**Epping to Thornleigh Third Track Proposal.** Application number SSI 5132.

I/we object to the Epping to Thornleigh Third Track Proposal and consider that the EIS is inadequate and does not address the full impact of this proposal. It will cause untold damage to the health of residents and to the fabric of the Beecroft Cheltenham Heritage Conservation Area. Do not approve this project, reconsider the alternatives and protect the community.

Figure 5.6 Cross-section and elevation - New Cheltenham Station concourse building
Note: Indicatively added to future design

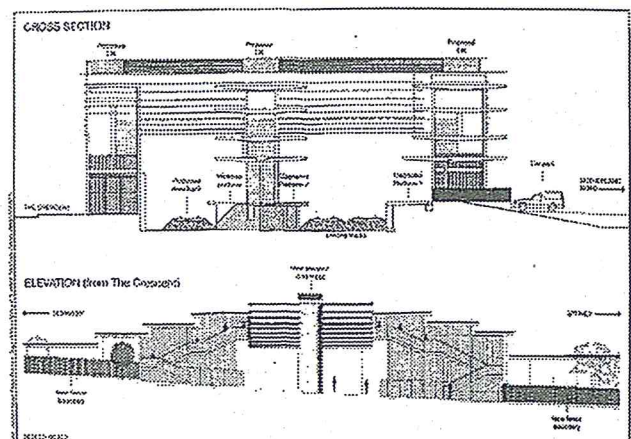
- The proposed redevelopment of Cheltenham Station shows no regard for the HCA. The visual impact of the proposed 13m high glass and steel concourse is totally unacceptable in this HCA.
